**Consultation Response from KC,
Highways Development Management**

2025/90517 land off, Forge Lane, Thornhill Lees, Dewsbury, WF12

**Outline application, including the consideration of access and layout, for two commercial units
(use class B2 and/or B8) and associated works**

Date Responded: 9-9-2025.

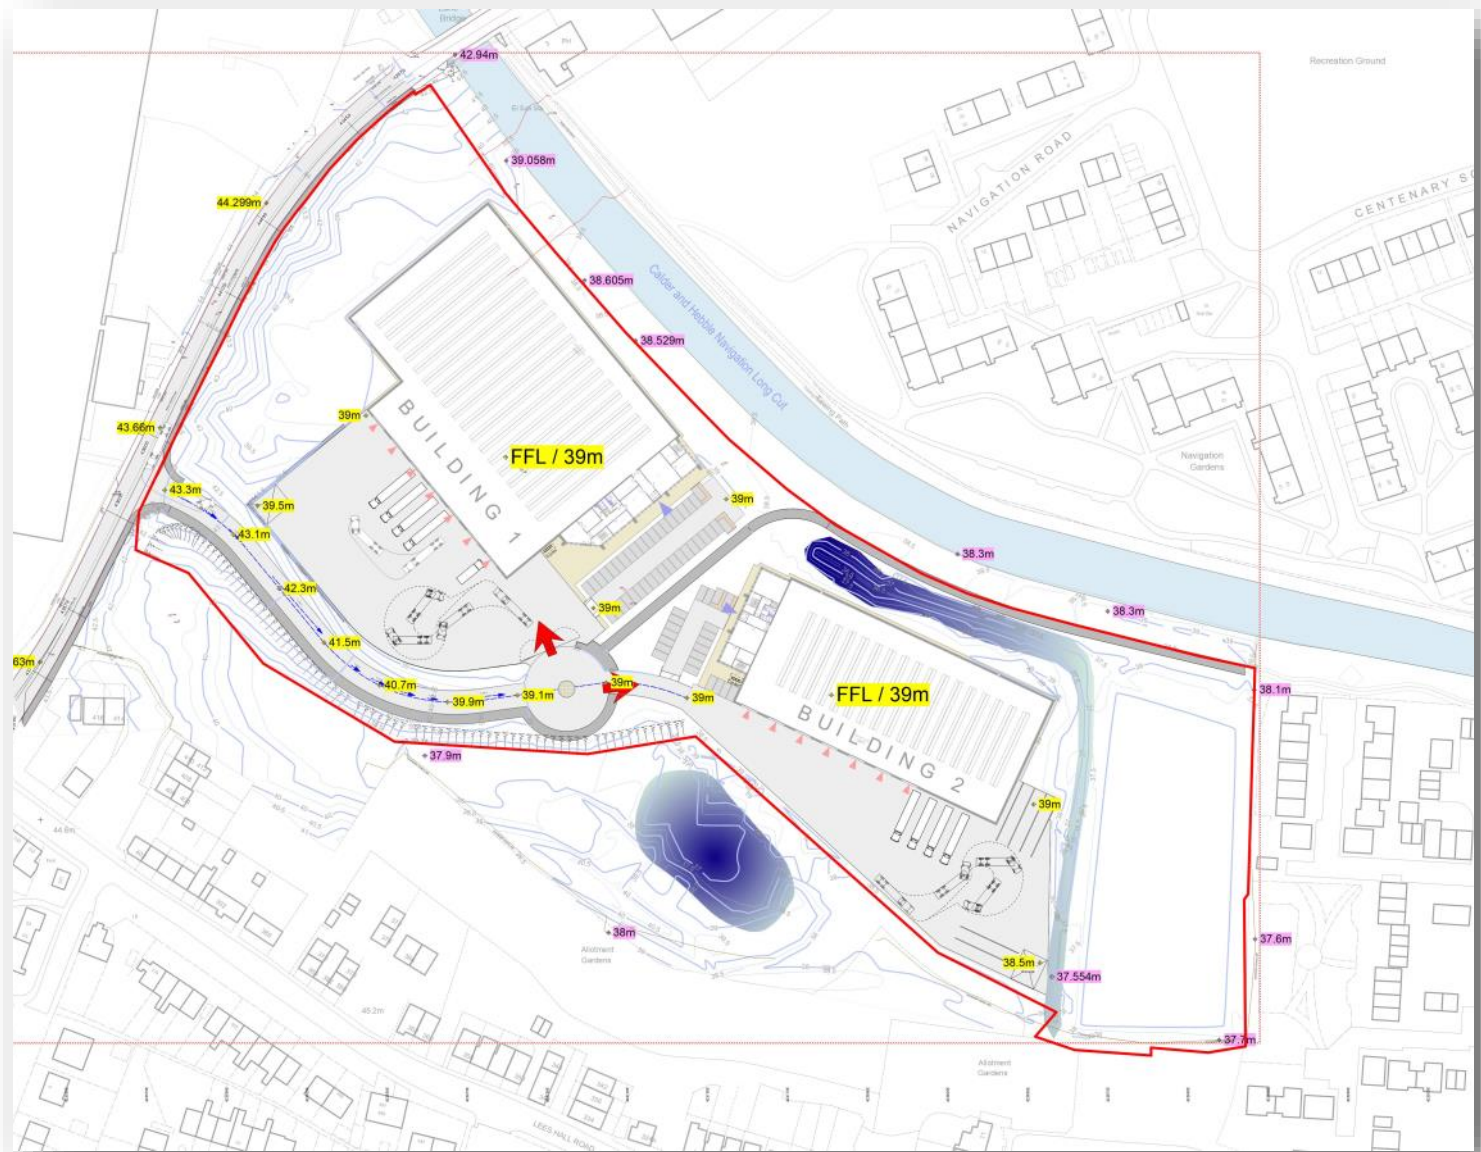
Footways and segregated cycleways will be required on both sides of the Industrial/Commercial Street type carriageways to a minimum width of 2.0m as per Table 2. There is currently only one footway shown to be provided on the southern side.

2, The footway to the site frontage should be shown to be widened to 3m to include a cycleway to tie into works planned at the Lees Hall Road/Ravensthorpe Road/Forge Lane junction.

3, A new east/west cycle link between Forge Lane and Brewery Lane via the existing path by Providence Court is shown. The cycle link should adhere to LTN 1/20 standards (width, surfacing, geometry etc).

4, There appears to be a gap between the eastern end of the proposed cycleway and the existing cycleway alongside Providence Court. The two cycleways need to be shown to meet.

5, Can the applicants be asked to explain why they have chosen to run the proposed cycleway through the site and not alongside the canal to the rear of building 1 and then on to Forge Lane.

8, Footways and segregated cycleways should be shown.

Drawing 16321-001

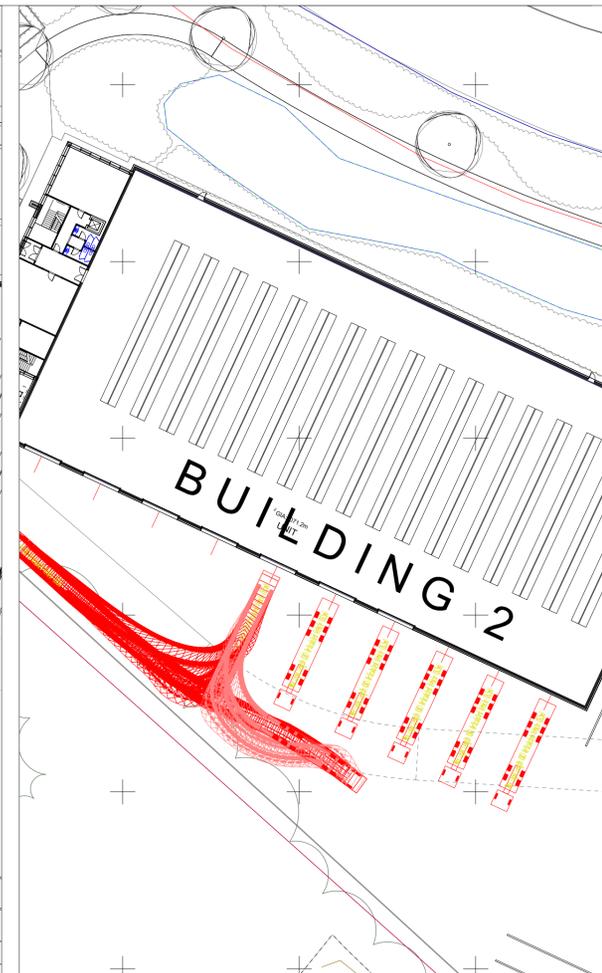
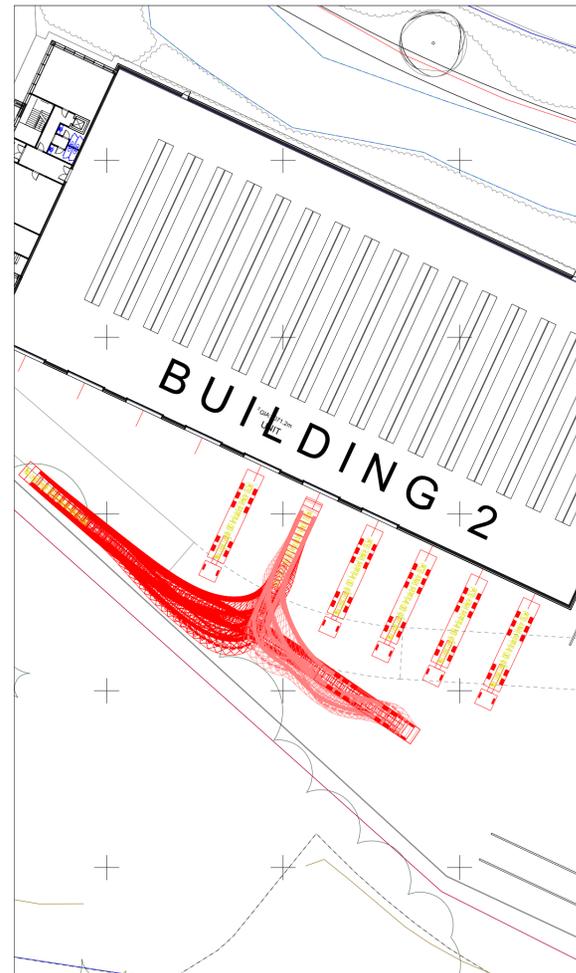
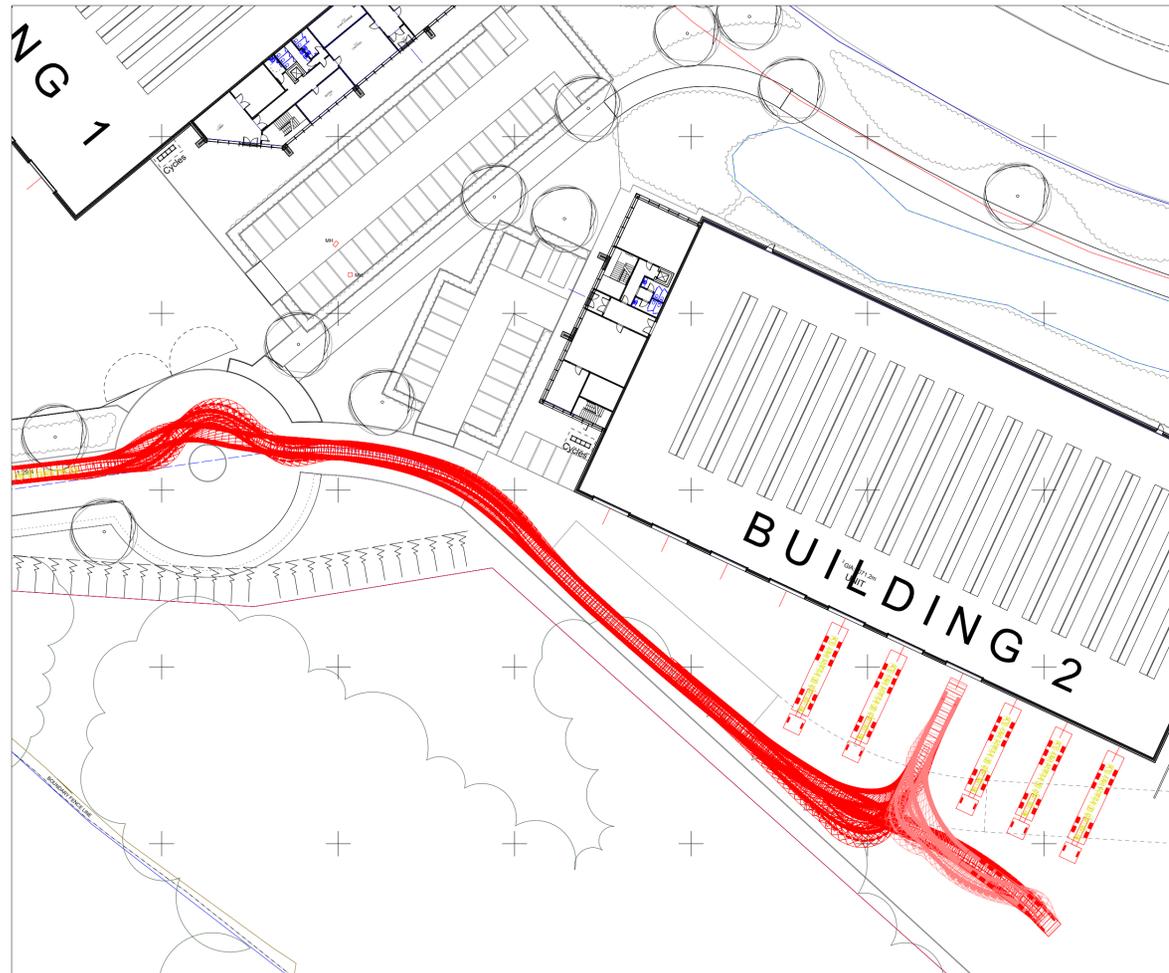
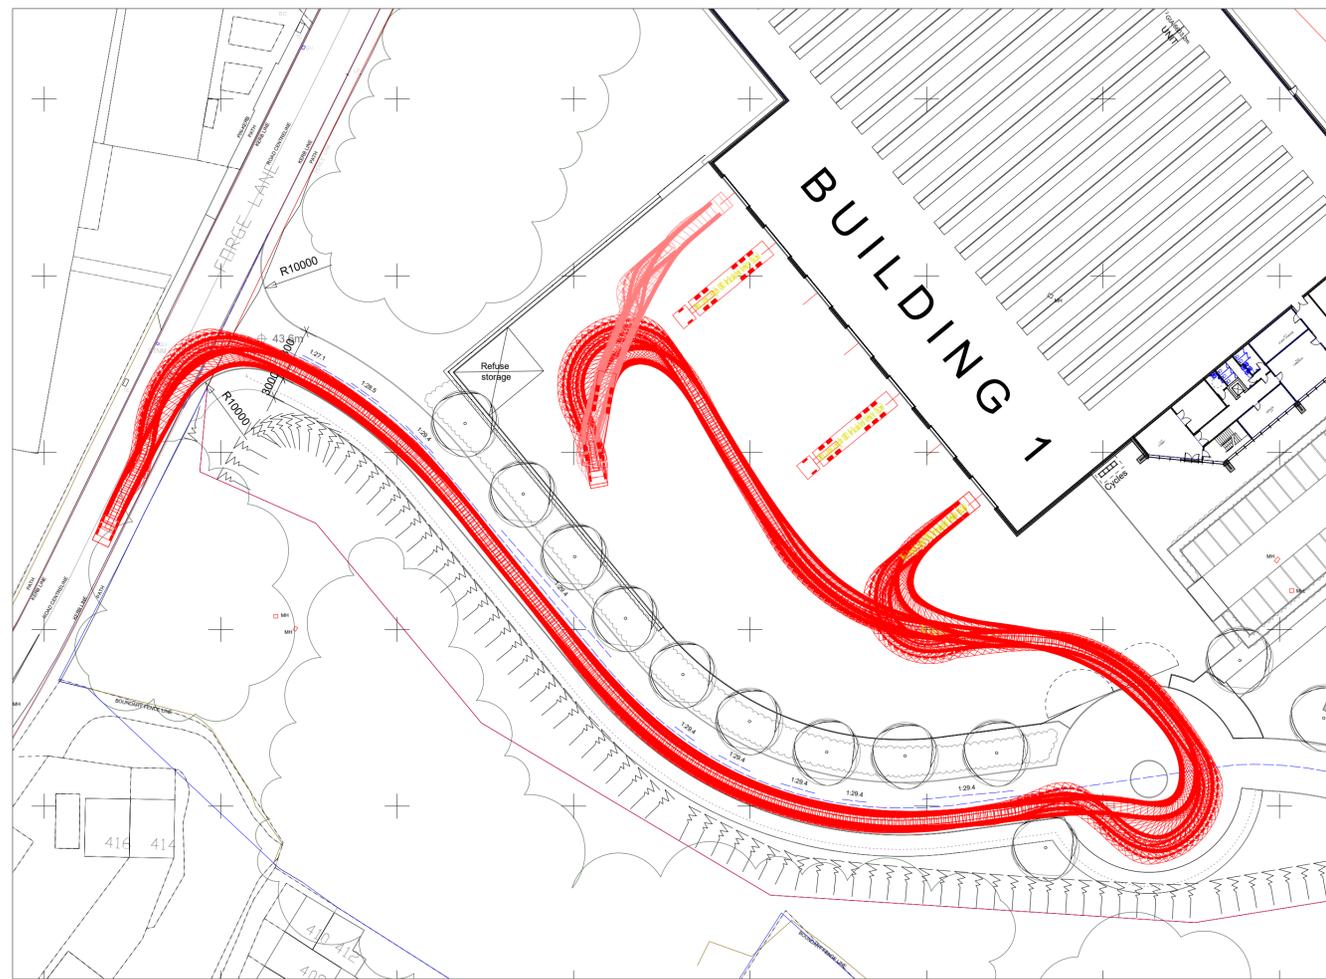
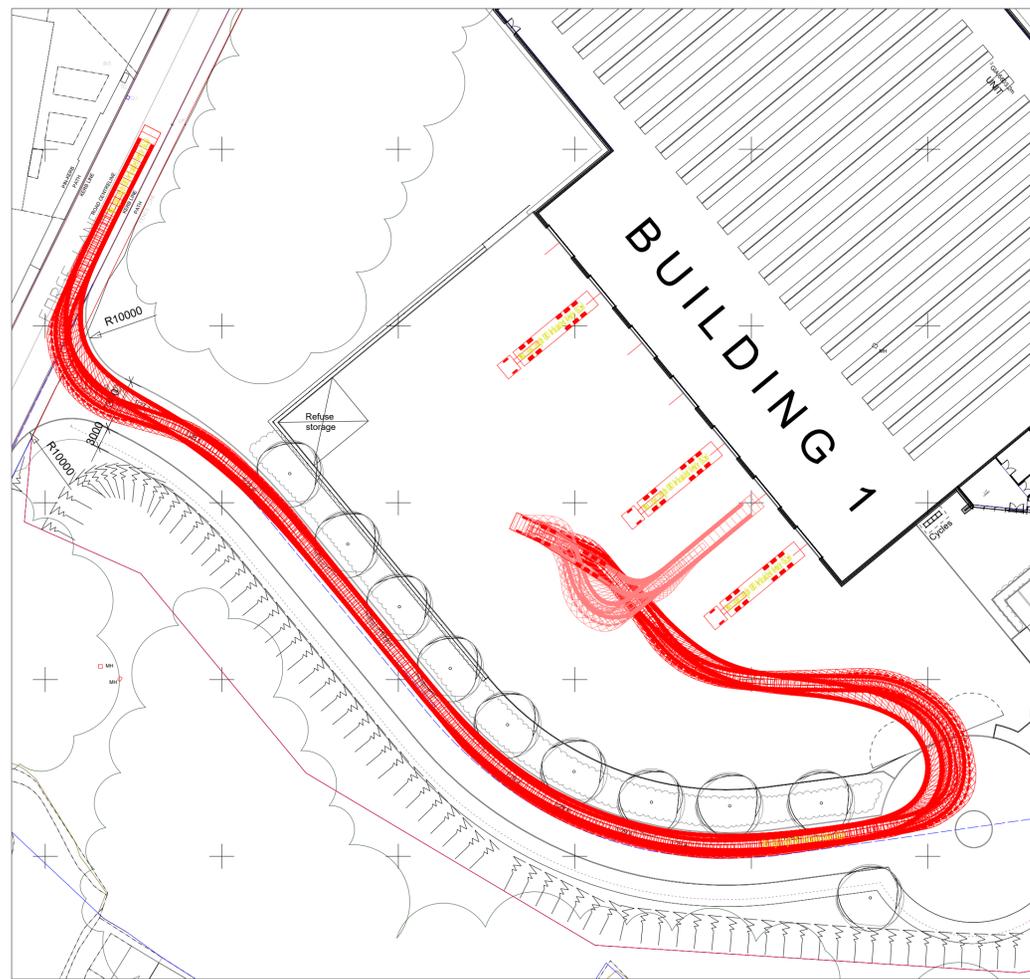
2, The swept path clearly shows that large HGVs would not be able to negotiate the junction on Forge Lane without lane encroachment, which could cause safety problems, both within the access and on Forge Lane. The Developer should use larger radii and/or tapers for the trailing paths of longer left-turning vehicles. This is likely to lead to a very wide junction mouth which would be difficult for pedestrians to negotiate, so a pedestrian refuge island in the junction mouth, with an informal crossing promoted by tactiles / flush kerbs should be considered.

6, The Developer should use larger radii and/or tapers for the trailing paths of longer left-turning vehicles and a pedestrian refuge island in the junction mouth, with an informal crossing promoted by tactiles / flush kerbs should be considered.
